**WELWYN HATFIELD BOROUGH COUNCIL
EXECUTIVE DIRECTOR - PLANNING, PUBLIC PROTECTION AND GOVERNANCE**

Application No: 6/2020/2119/PN8
Location: 24 Worcester Road Hatfield AL10 0DX
Proposal: Prior approval for the erection of a single storey rear extension 6m in depth, 3.7m in height and 2.7m eaves height
Officer: Mr Tom Gabriel

Recommendation: Prior Approval Refused

TITLE OF DRAWING
Existing & Proposed Floor Plans & Elevations

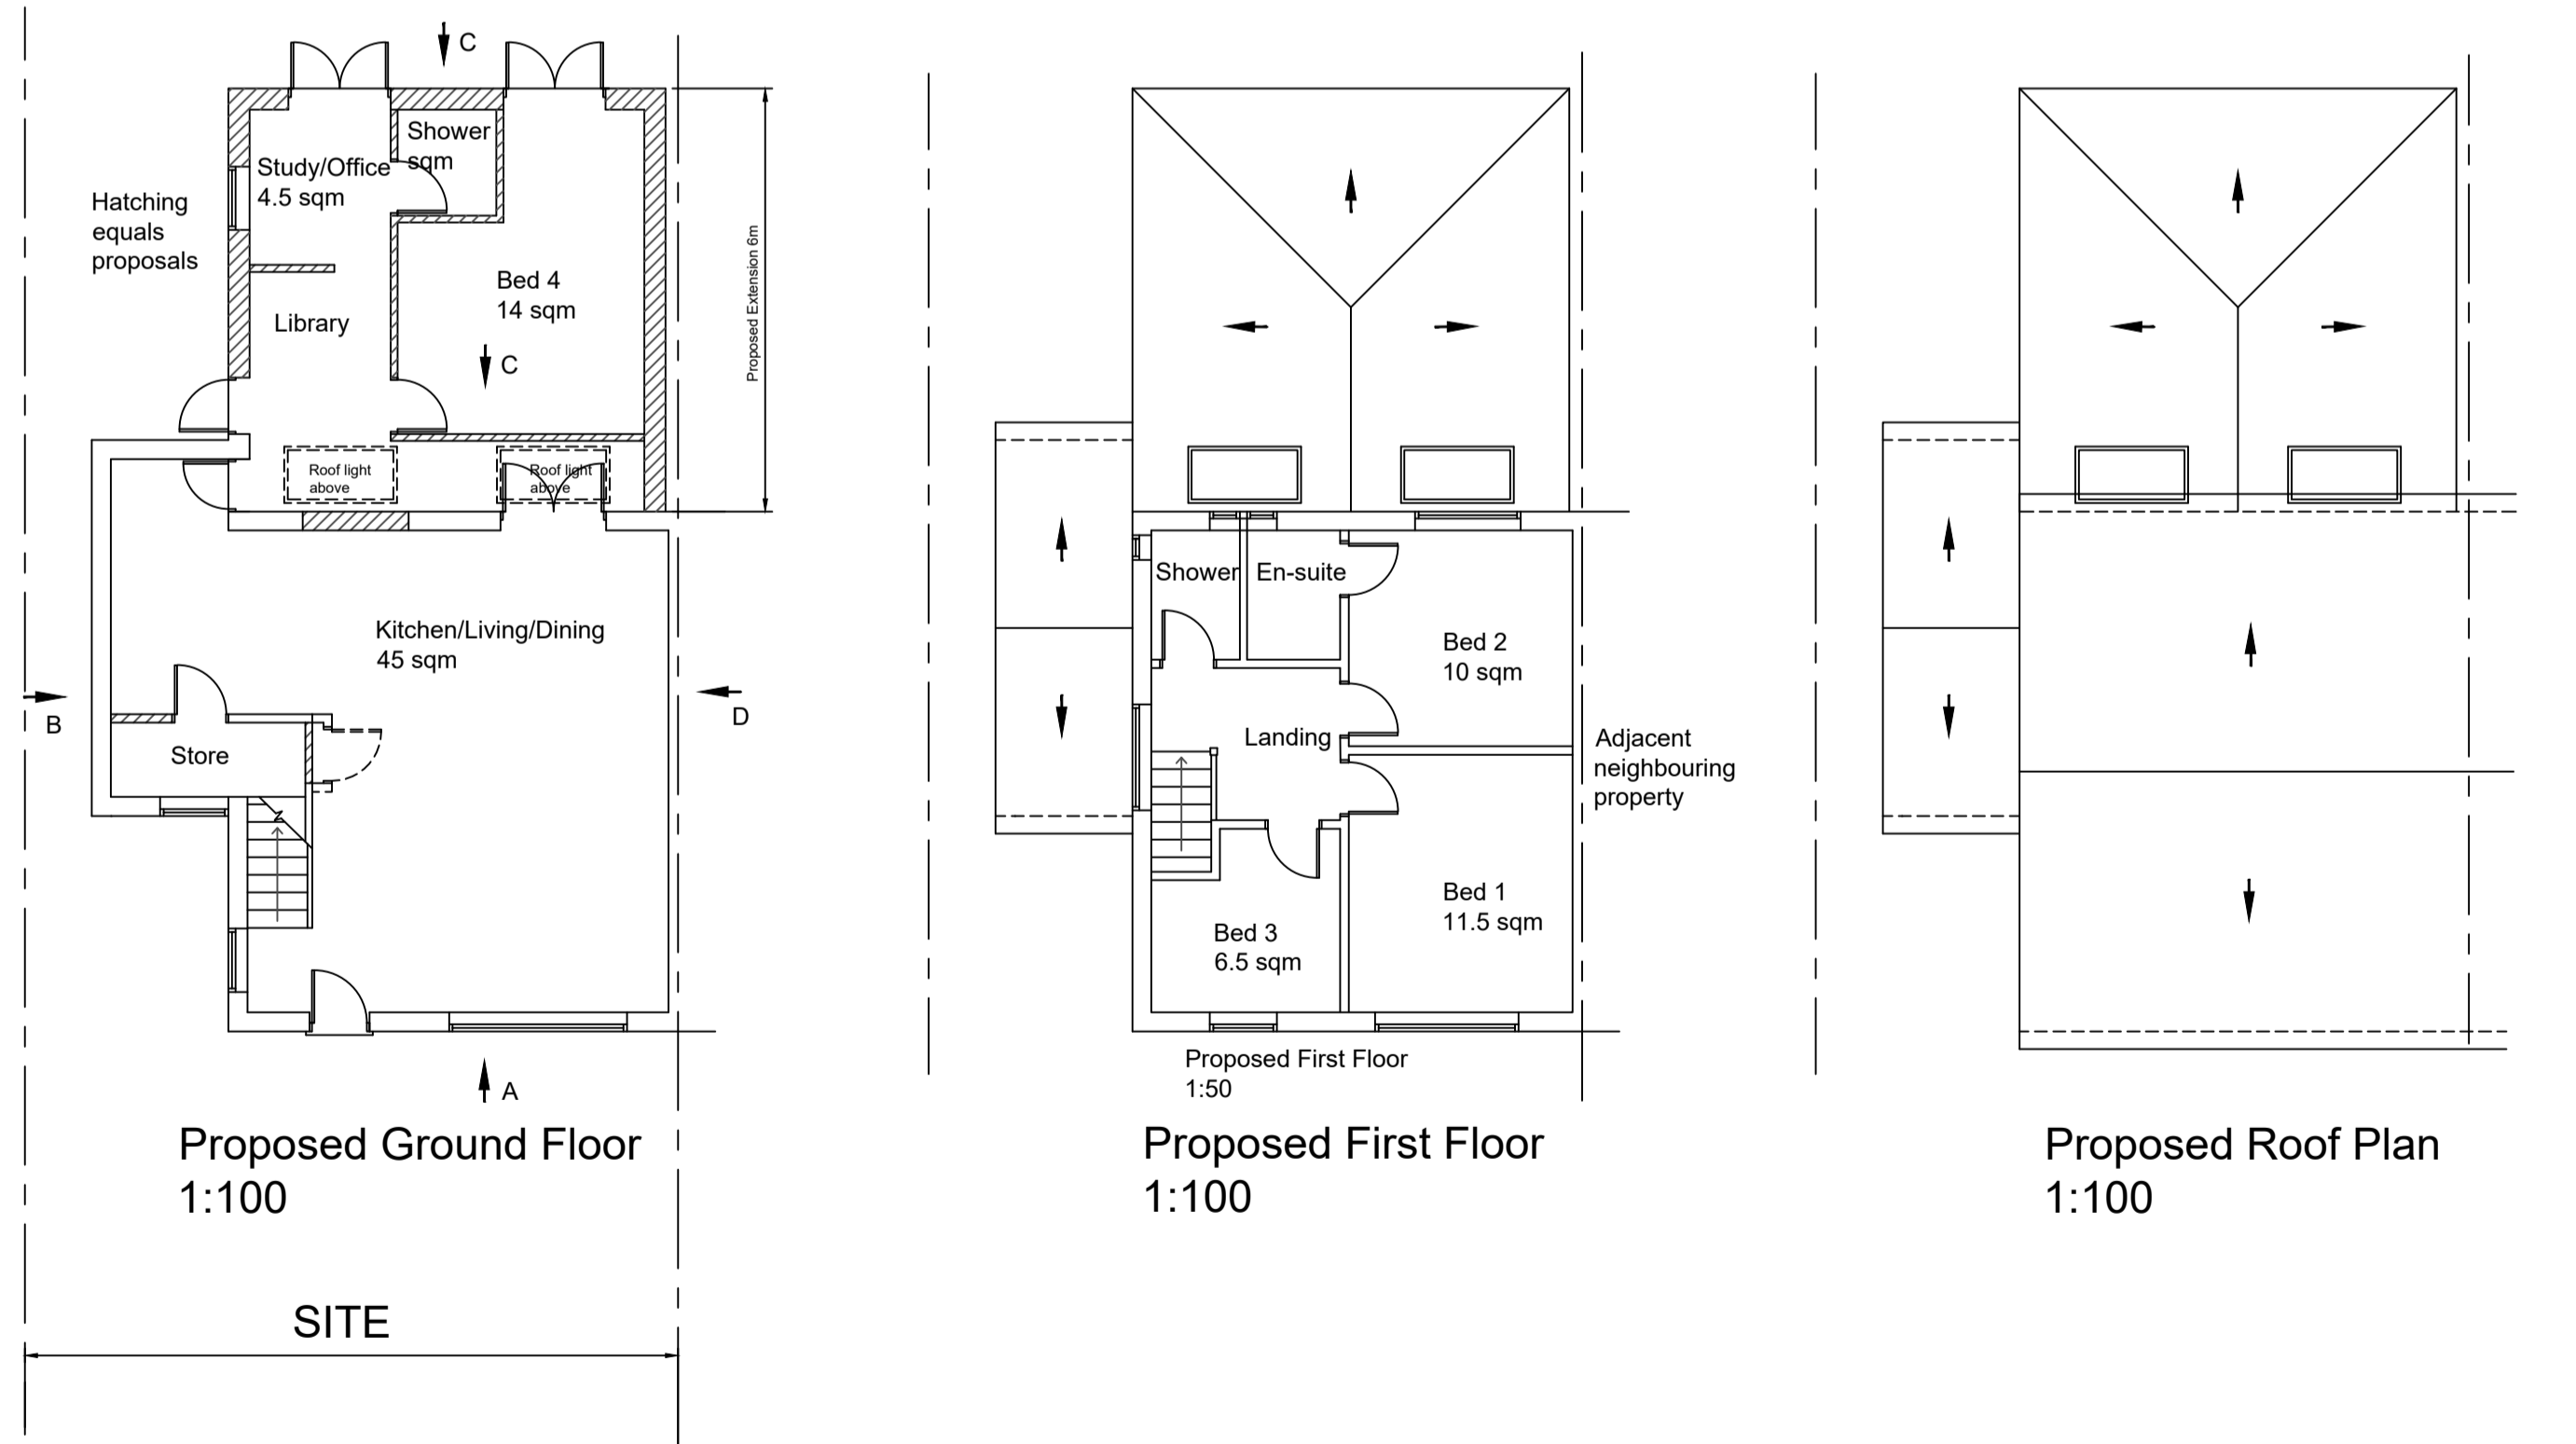
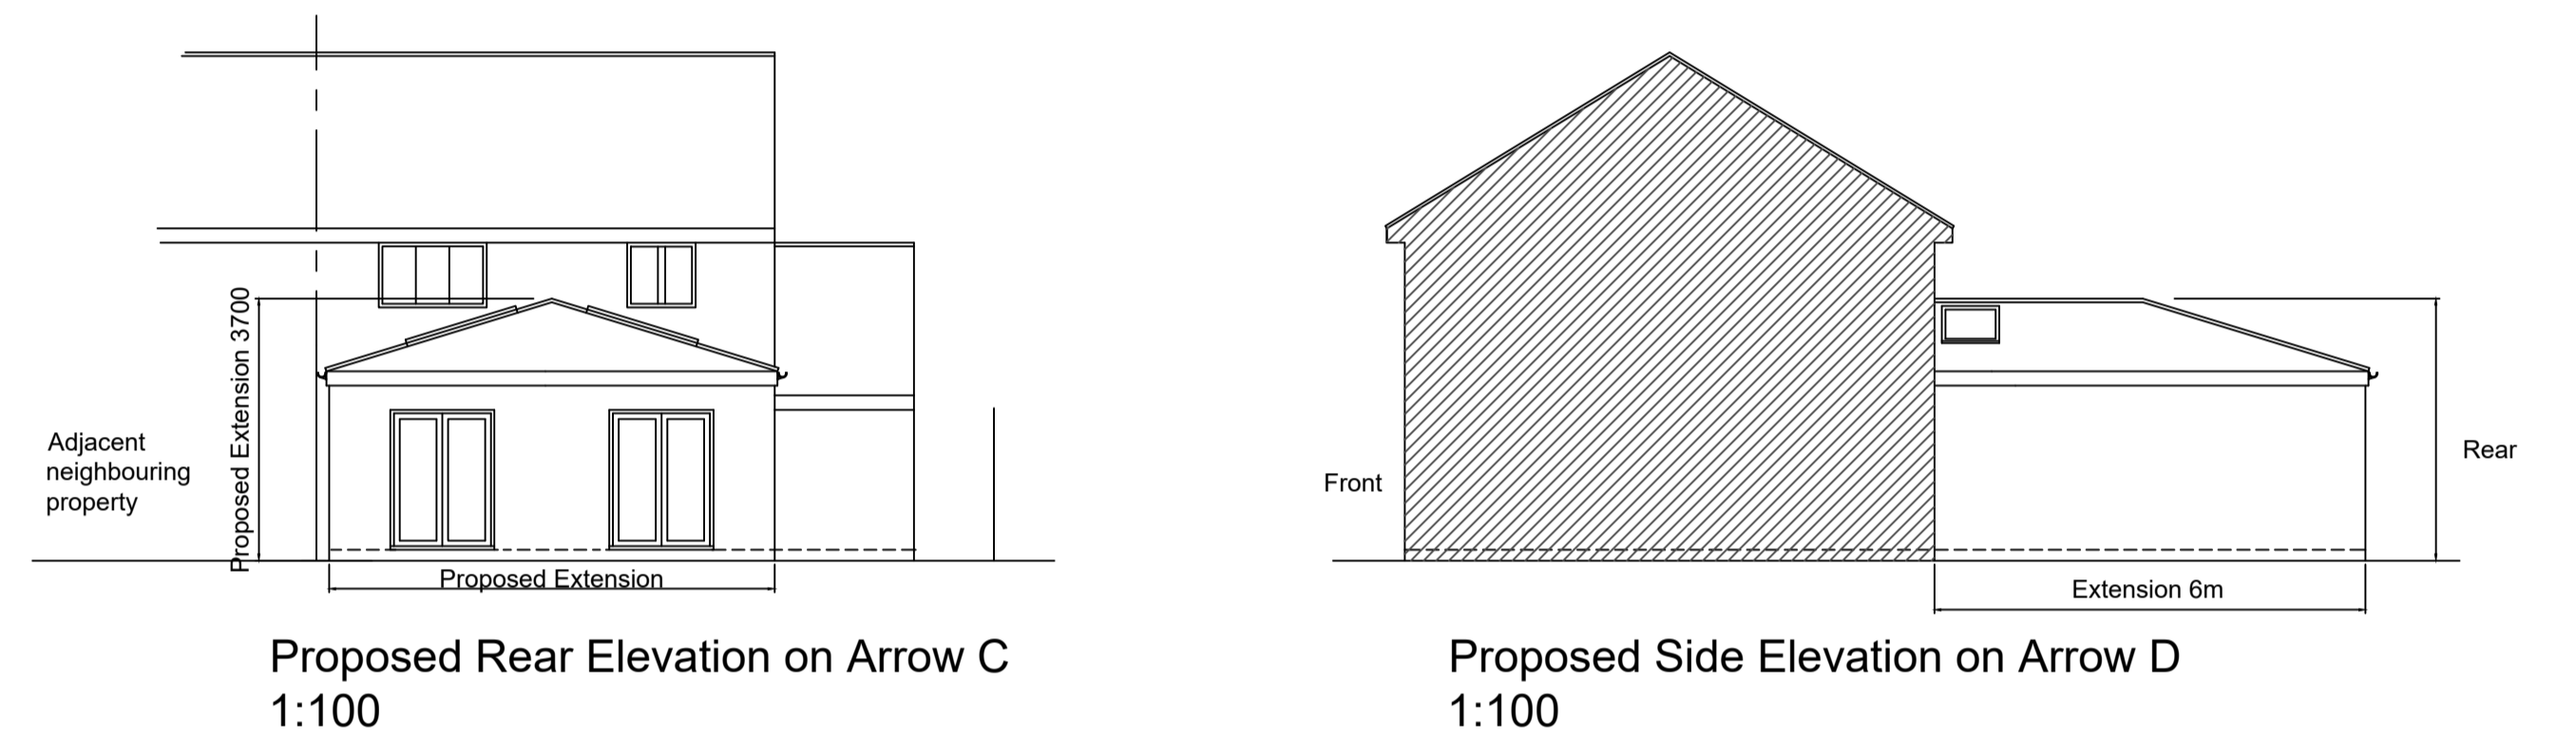
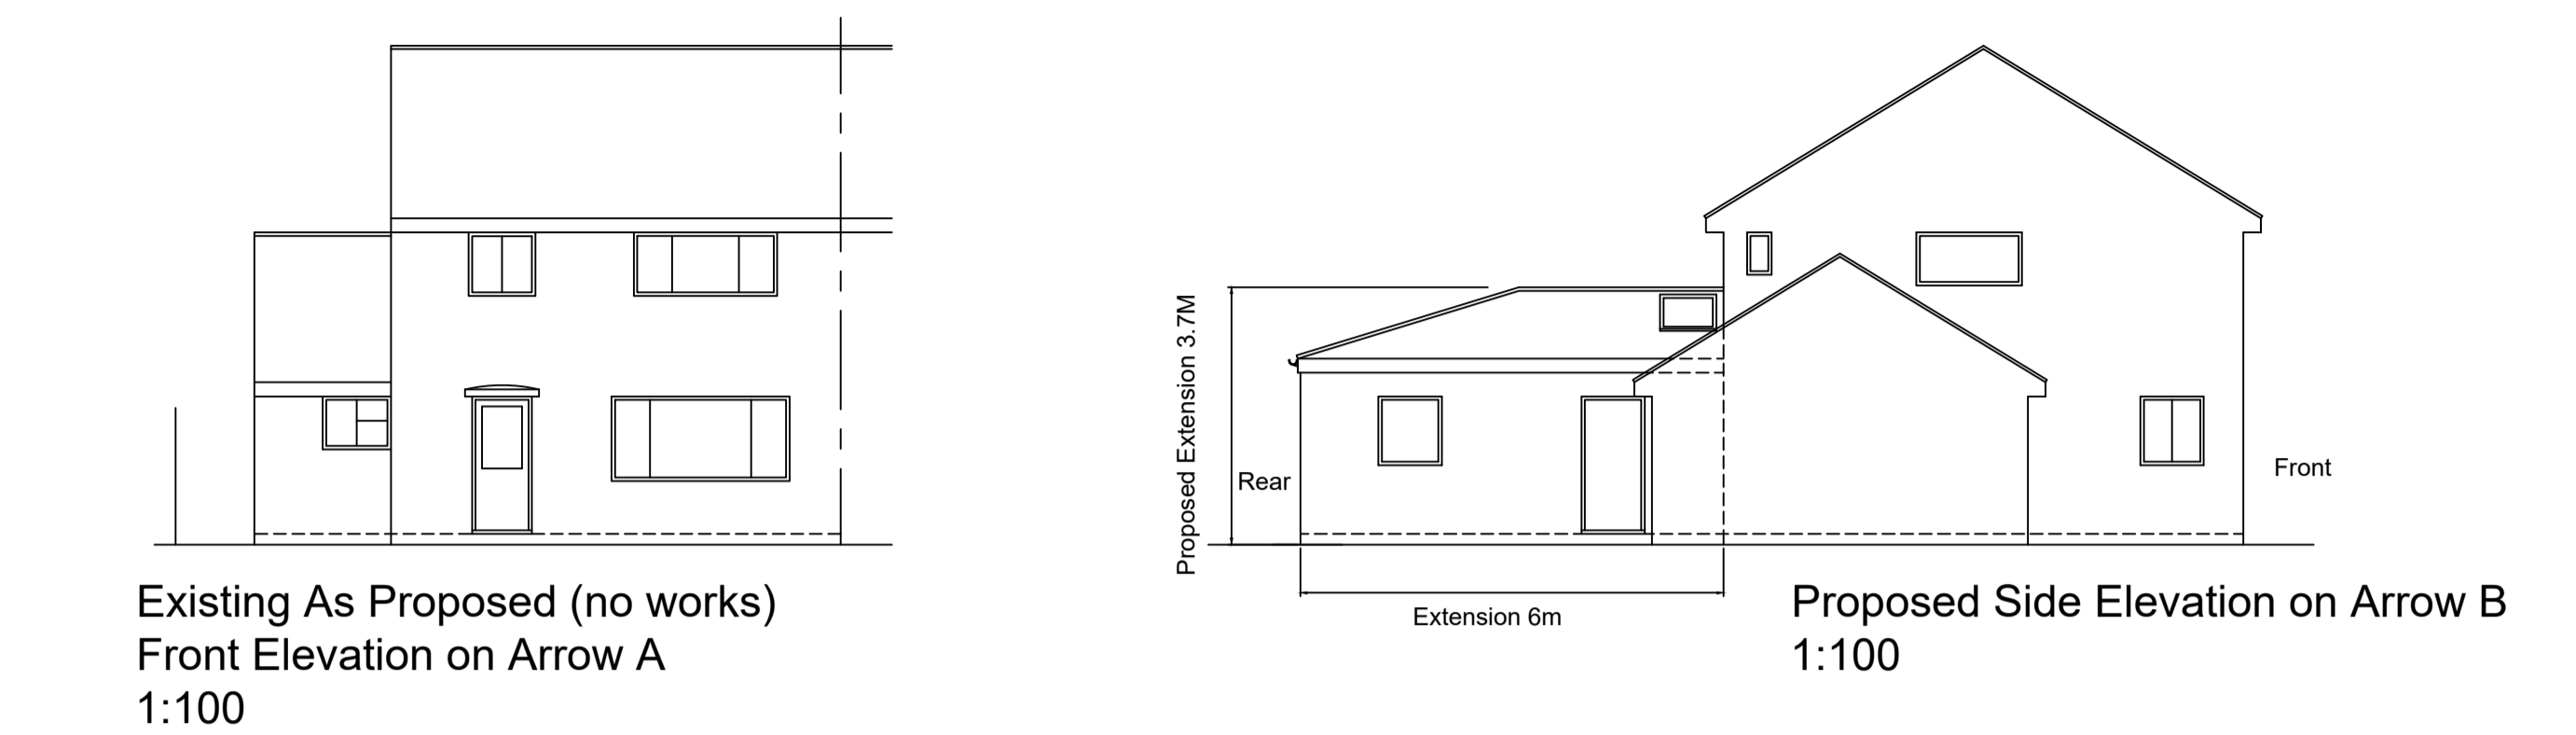
(j) would the enlarged part of the dwellinghouse extend beyond a wall forming a side elevation of the original dwellinghouse, and:- (i) exceed 4 metres in height, (ii) have more than one storey, or (iii) have a width greater than half the width of the original dwellinghouse The existing single storey side/ rear projection at the dwelling appears to be an original part of the building as its materials and those of the dwelling match and there are corresponding elements at many of the neighbouring and surrounding dwellings. On this basis, it is considered that the single storey side/ rear element of the dwelling is an original part of the dwelling. While the proposed extension would attach to this side/ rear element of the dwelling, it would not extend beyond a wall forming a side elevation of the original dwellinghouse as the side/ rear element is original. The extension would not form a 'wraparound' extension.	Y	N

The proposed extension would extend beyond a side wall and therefore falls to be considered against the limitations set out in paragraph A.1(j) of the GPDO. Notwithstanding that the proposed extension would comply with the limitations set out in paragraph A.1(g), the construction of paragraph A.1 is such that development is not permitted by Class A if it fails to meet any of the clauses (a) – (k). As the extension would have a width greater than half the width of the original dwelling/house it would exceed the limitation on the width set out in clause (iii) of paragraph A.1(j). Therefore, the proposal is not permitted development and an application for planning permission is required.

1. The proposed development fails to comply with the Schedule 2, Part 1, Class A.1(j) of the General Permitted Development Order 2015, as amended. The reason for this is because the proposed extension would have a width greater than half the width of the original dwellinghouse.
